RE: ENGINEER CERTIFICATION FOR PHILLIPS 66 @ EUBANK & LOMAS (J21-D38)
CERTIFICATION STATEMENT DATED 7/22/97

**RE: PHILLIPS 66 - EUBANK AND LOMAS (J21-D38). GRADING AND DRAINAGE
PLAN FOR BUILDING PERMIT APPROVAL. ENGINEER'S STAMP DATED
FEBRUARY 10, 1997.**

RE: PHILLIPS 66 EUBANK & LOMAS J21-D38

RE: DRAINAGE PLAN FOR PHILLIPS 66 (J21-D38) ENGINEER'S STAMP DATED 1/16/97

GRADING & DRAINAGE PLAN

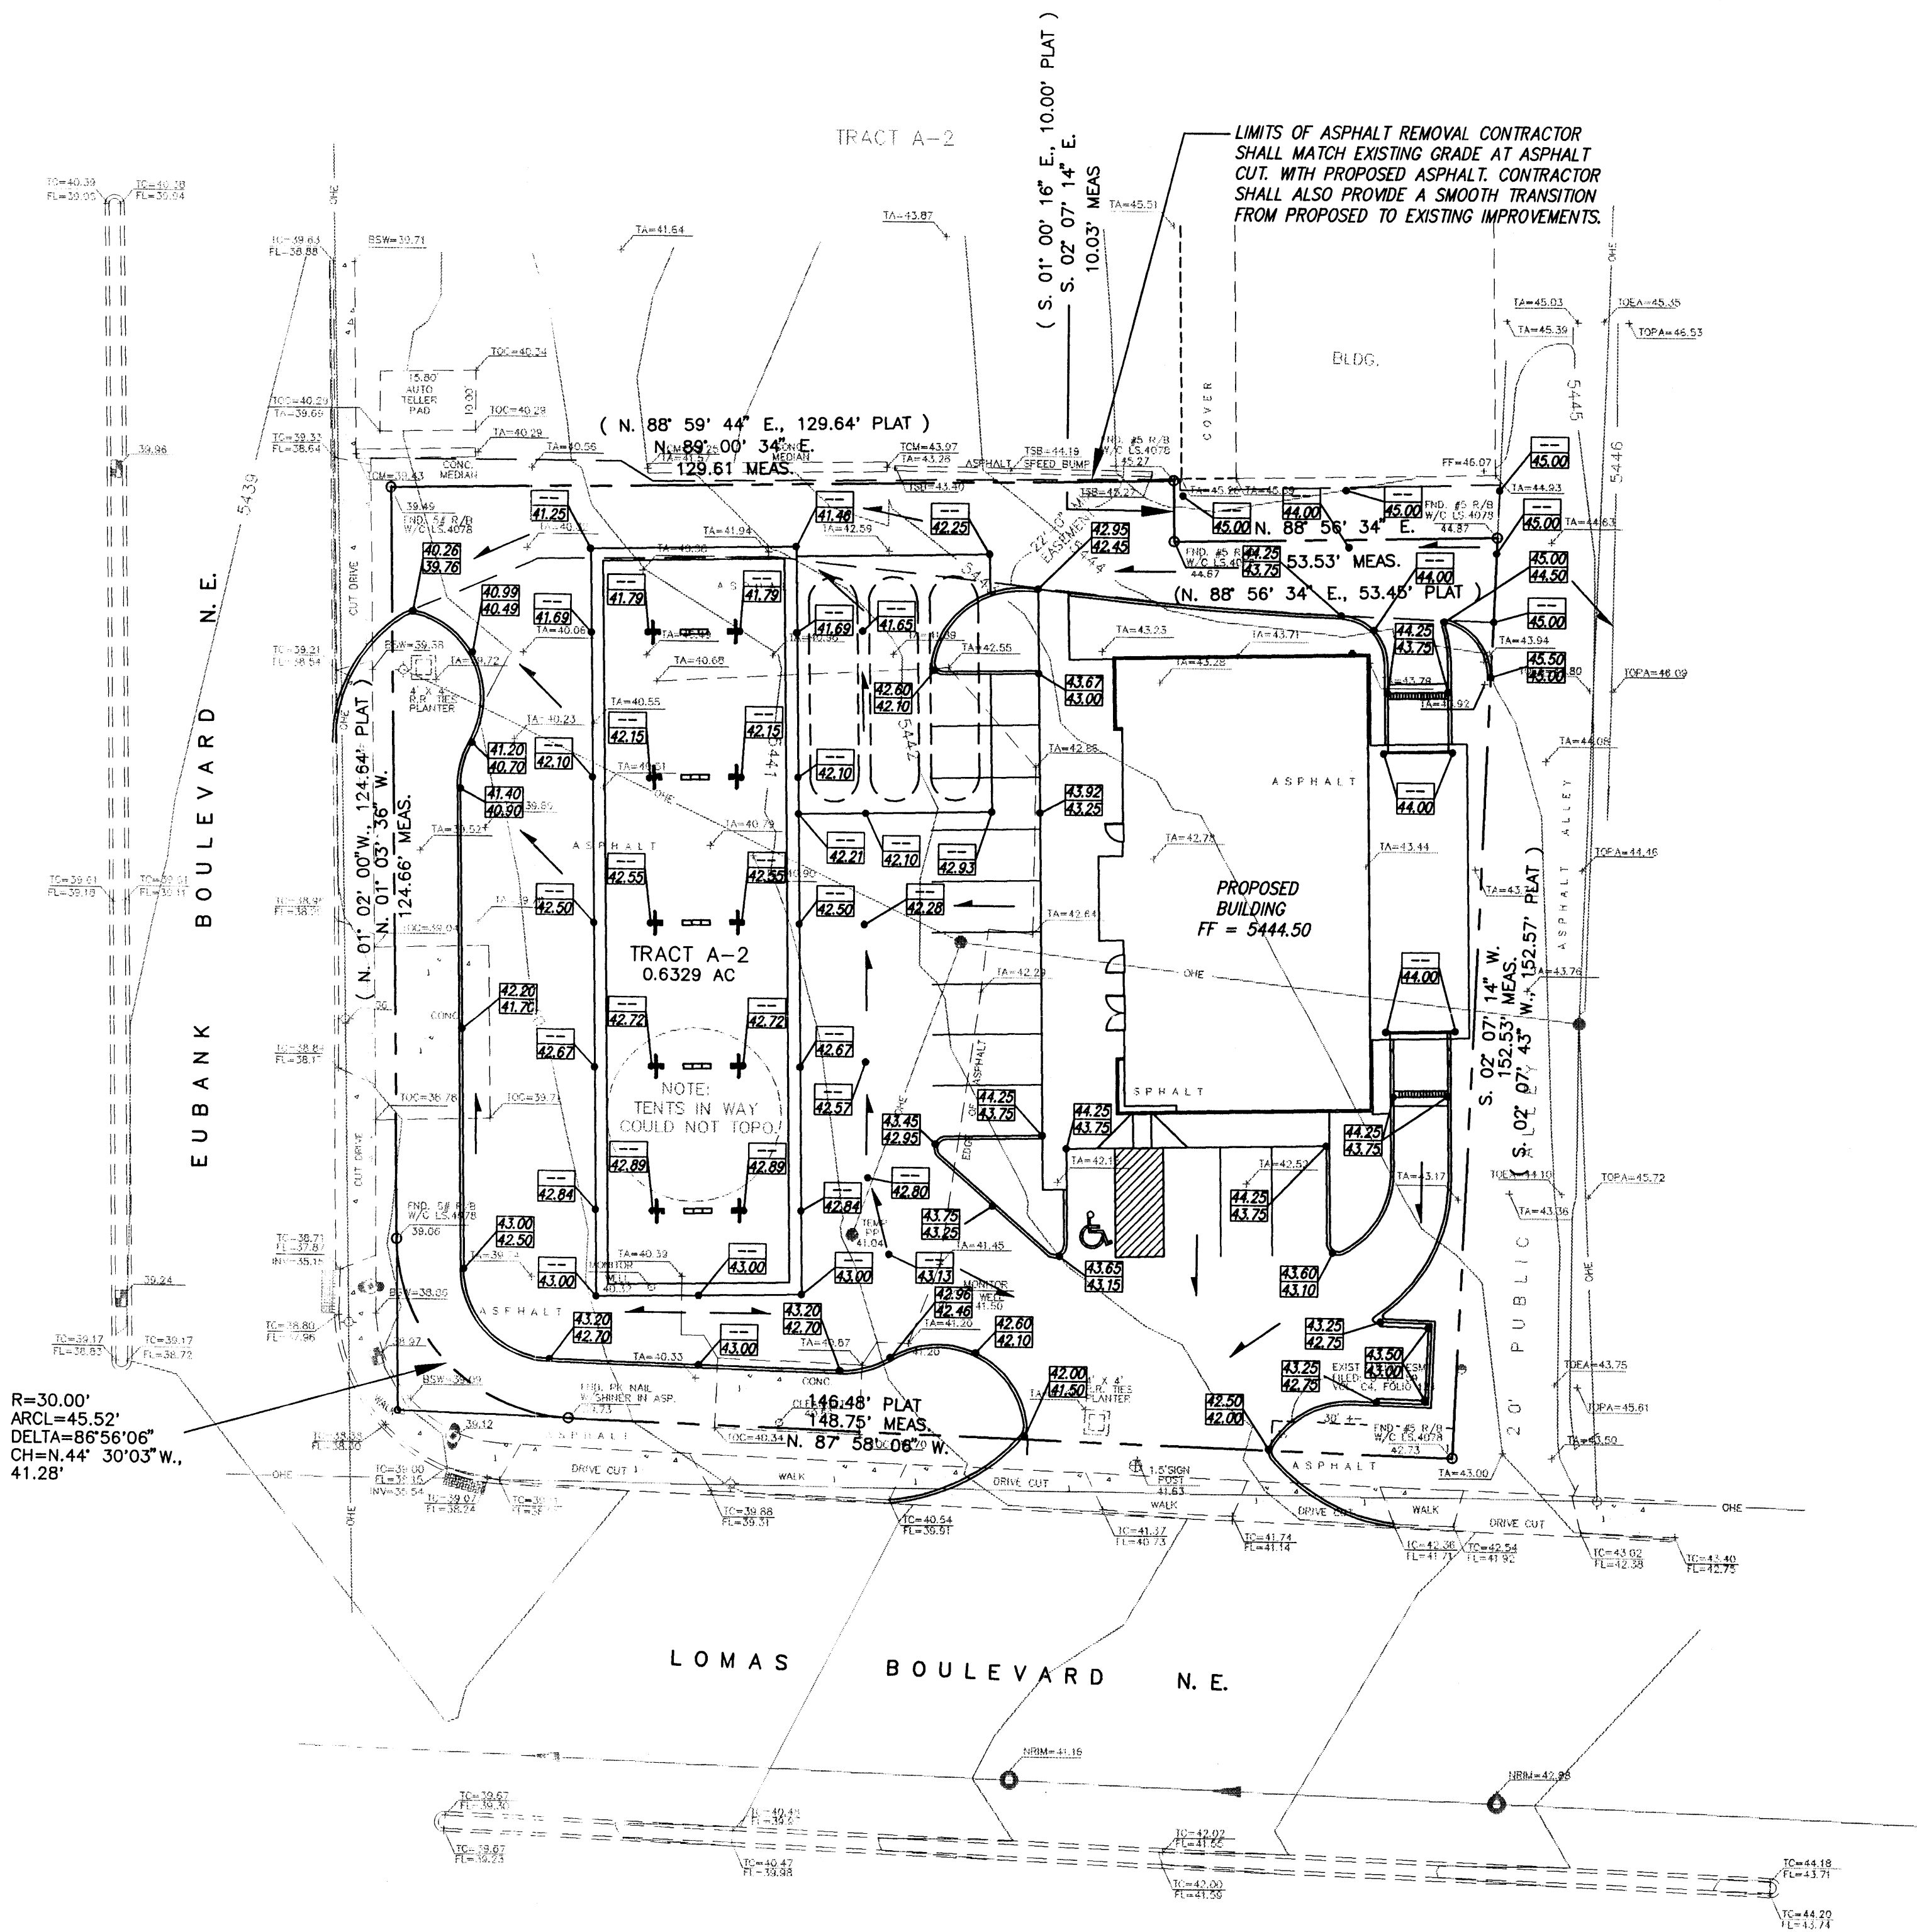
Based on the information provided on your January 16, 1997 submittal, listed are some concerns that will need to be addressed prior to approval:

1. Location and direction of the roof drains.
 2. Condition of the existing alley. Is the alley to city standards?
- If I can be of further assistance, please feel free to contact me at 924-3986.
